Australian Technology Park Redevelopment SSD 7317

Submission to NSW Planning and Environment
9 March 2016

City of Sydney

extent of detail shadow study:

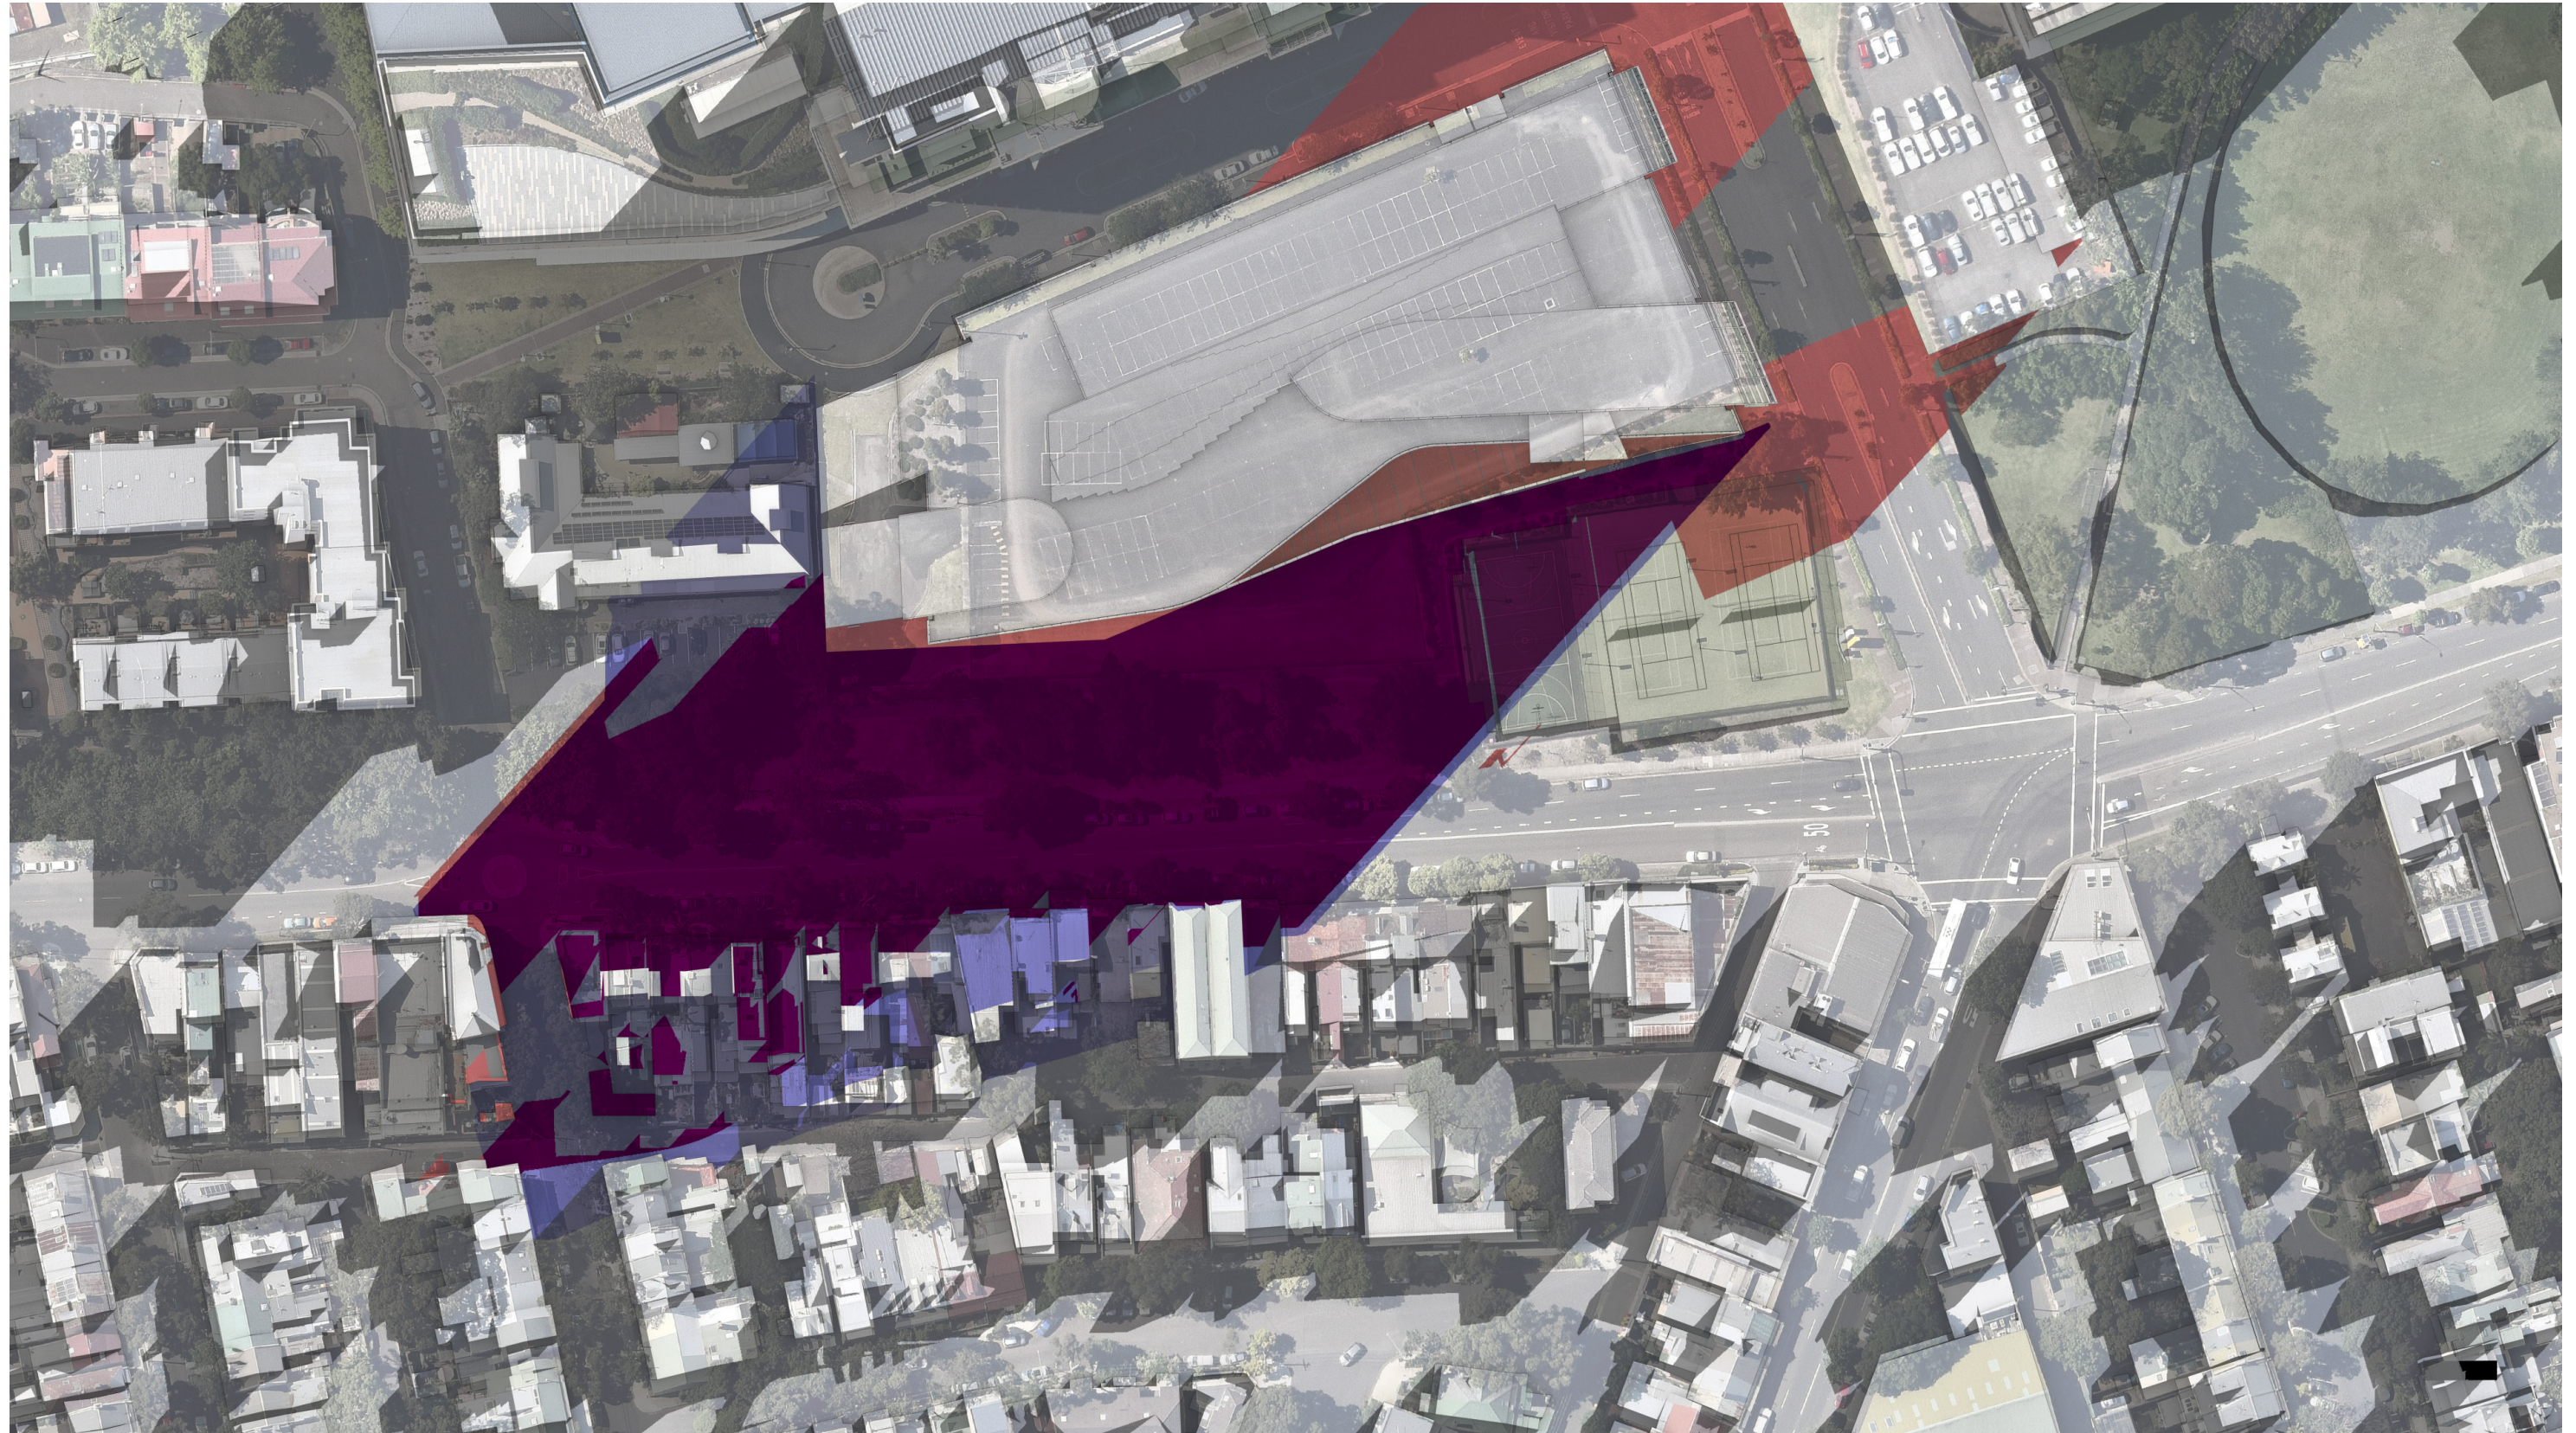
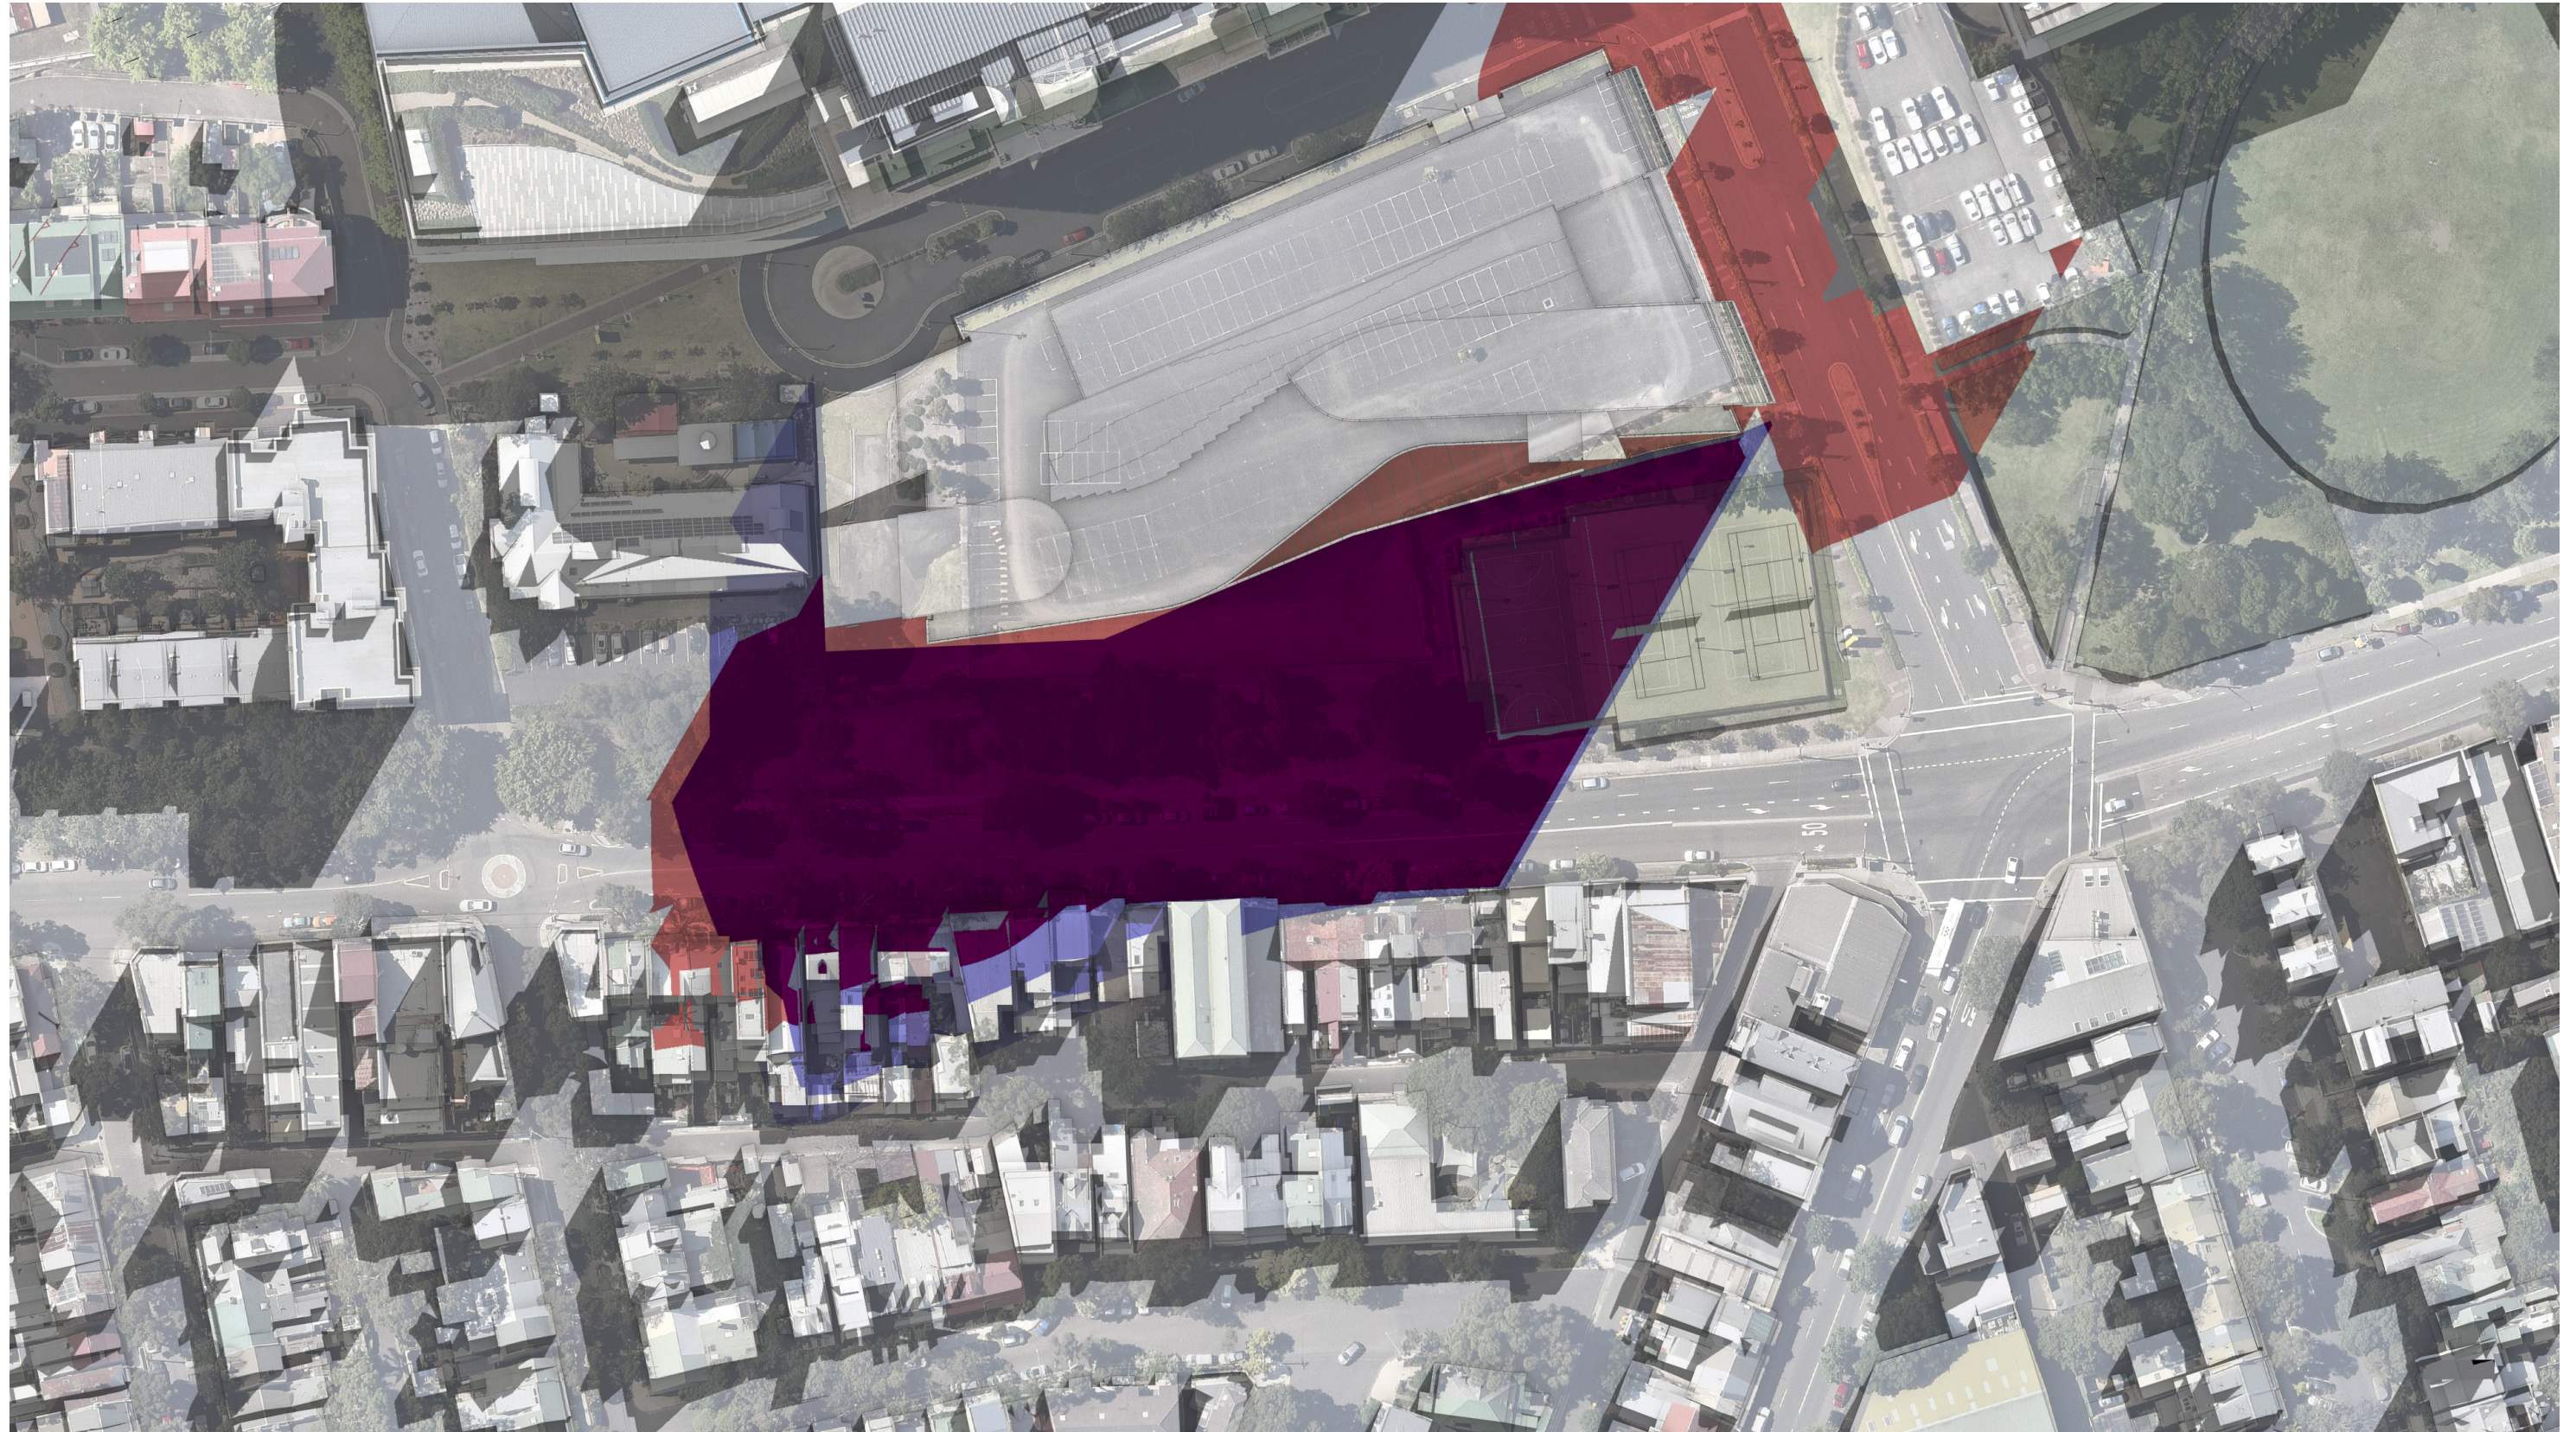
The additional bulk and scale of the building at the western edge results in adverse additional overshadowing of properties along Henderson Road, many of which would not be overshadowed at all with a compliance scheme and many of which would get afternoon relief from overshadowing with a compliant scheme.

The existing 4-storey height control should be stayed and Building 1 height reduced from 9 storeys to 4 storeys by redistribution of GFA to create a more appropriate scale shift to development to the west and reduce overshadowing and visual impacts on surrounding properties to the west and south.
